Consultation Response from KC, Highways Development Management
2024/90346 Future House, Pheasant Drive, Birstall, Batley, WF17 9LT
Change of use to Class B2 for use as industrial transport yard, with associated new office building, new fencing including new pedestrian and vehicular gates, widening of vehicular access, including re-surfacing of yard and access threshold, and new lighting to yard
Date Responded: 2-7-2024. Responding Officer: Mark Berry Responding Ref: 13-9SW-9

drawing number  
 KH855-101

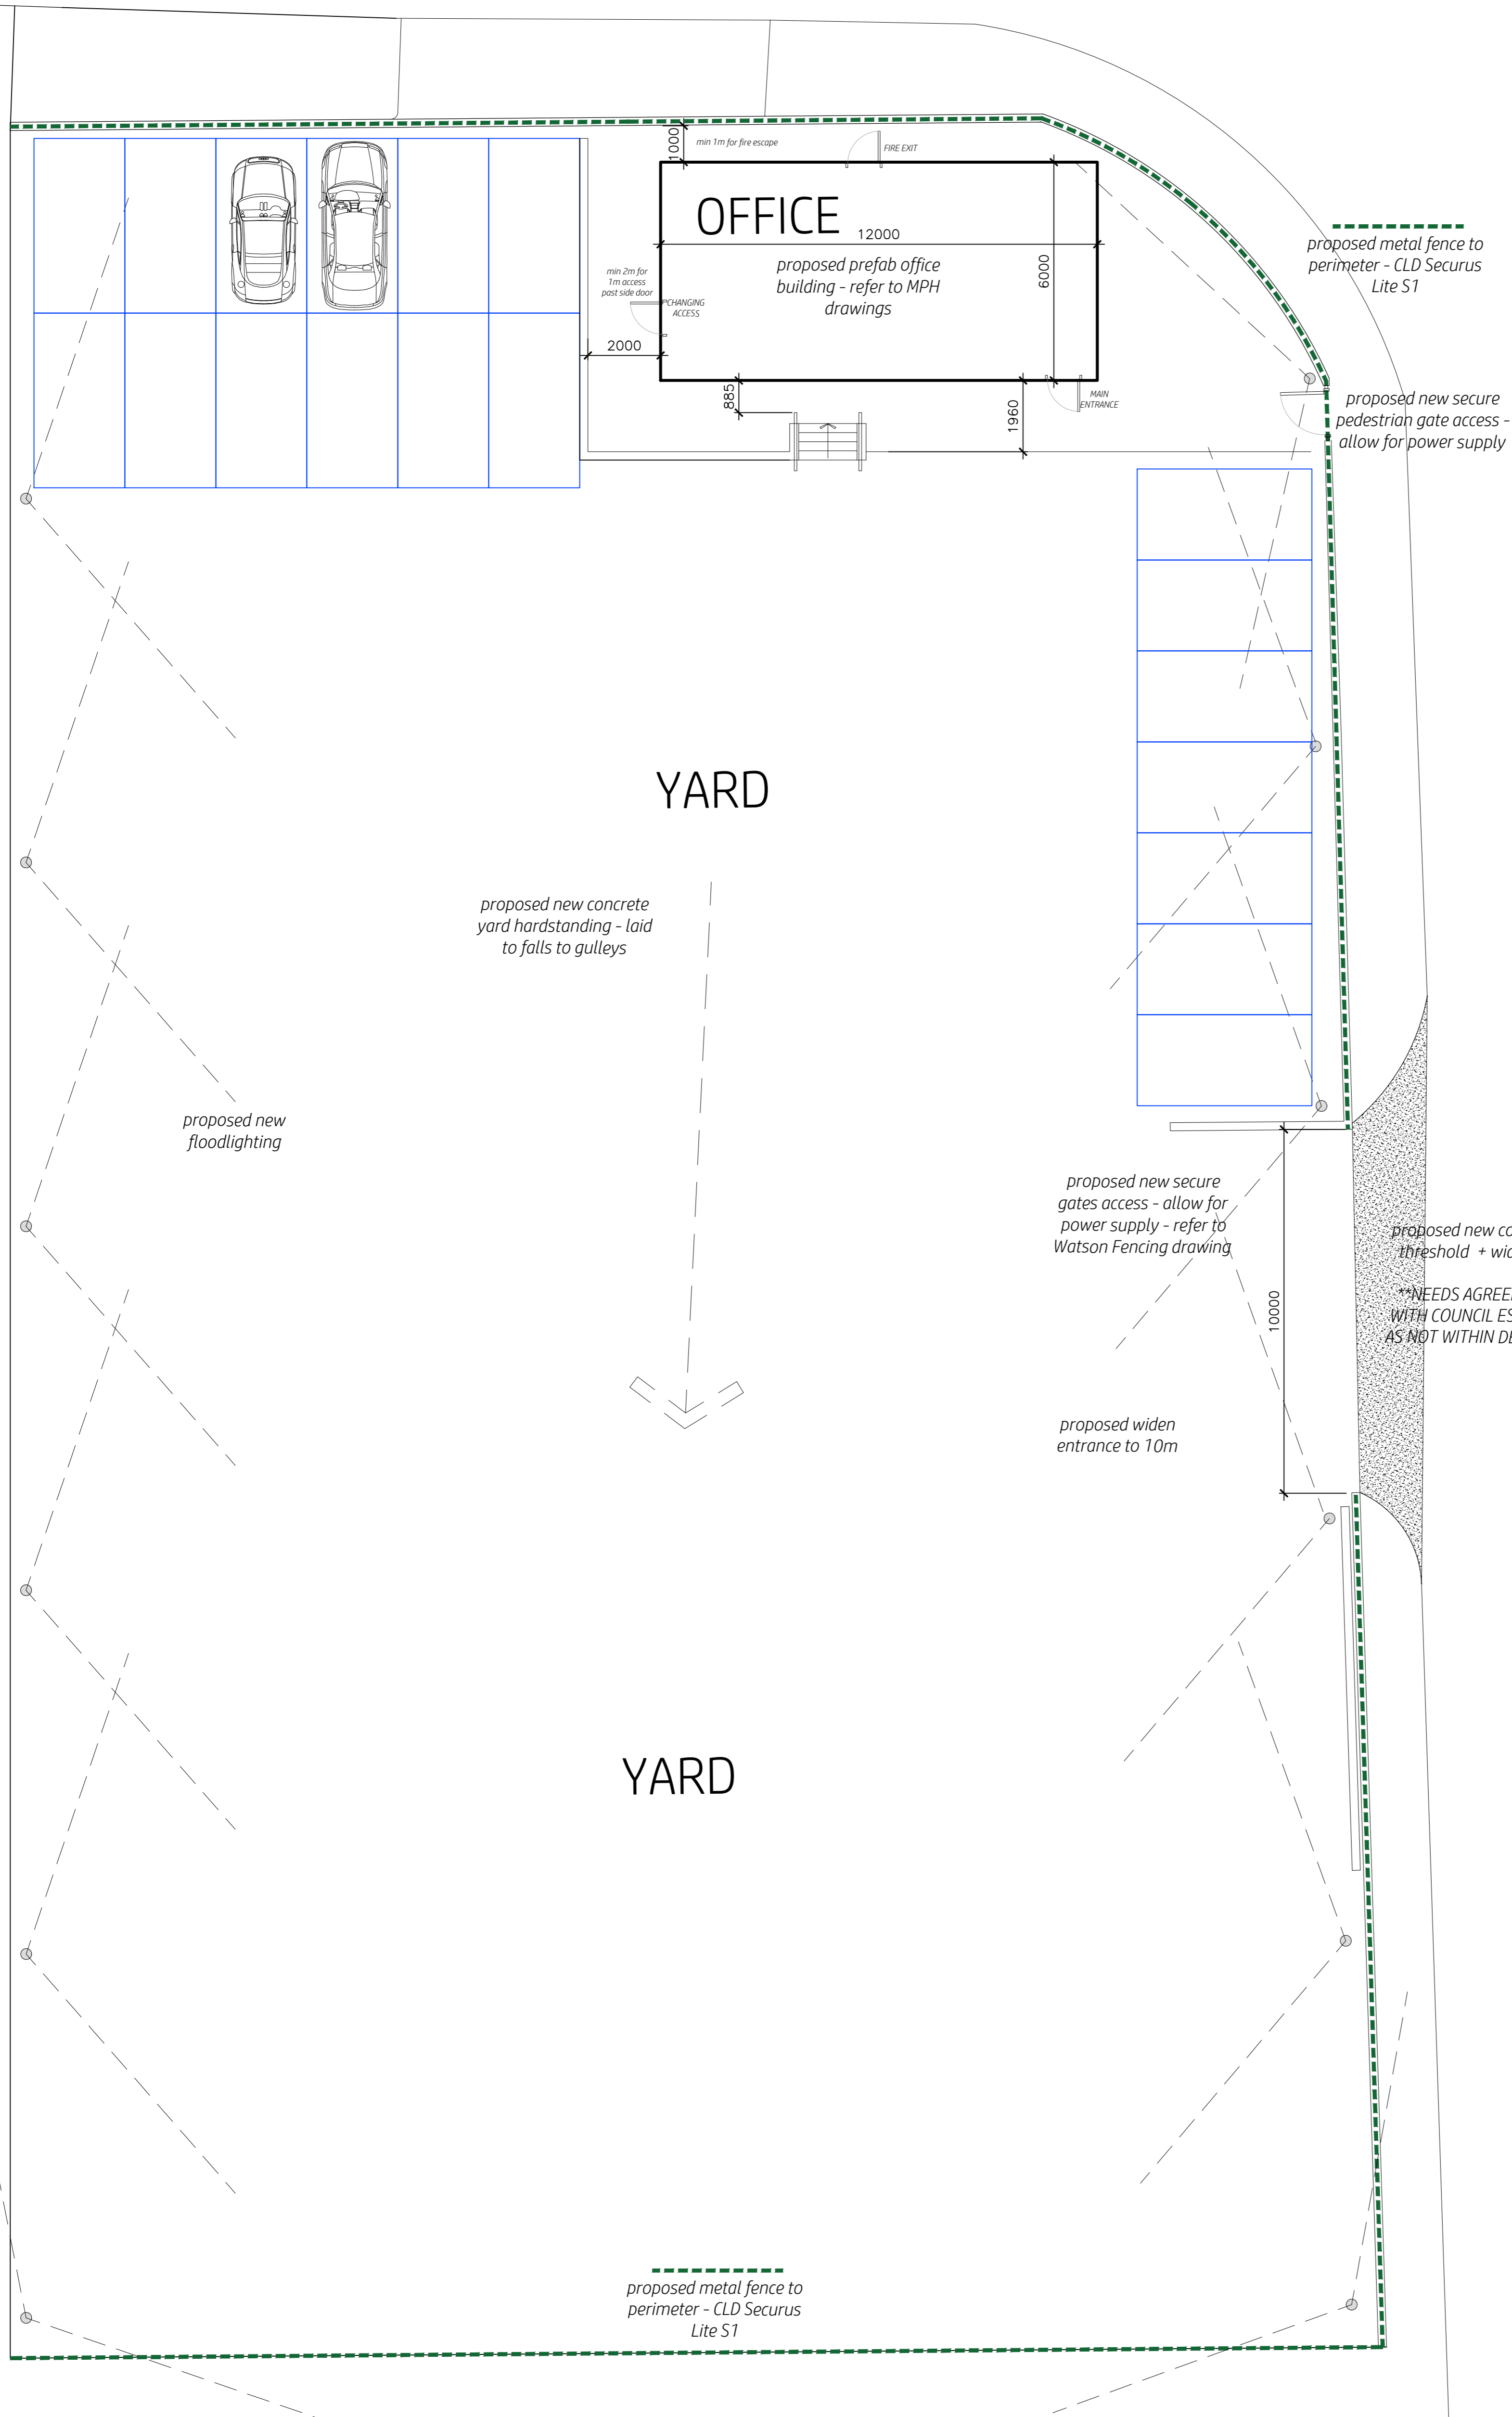
The applicants were asked to explain how this proposal will operate and provide details of the numbers of HGVs that will operate from the premises together with details of their parking arrangements. They were also asked to provide vehicle swept paths to demonstrate that the largest vehicle anticipated to access this site regularly (16.5m articulated lorry) can enter and exit from Pheasant Drive and turn within the site.

No information is however provided to explain how this proposal will operate or details of the numbers of HGVs and their parking arrangements.
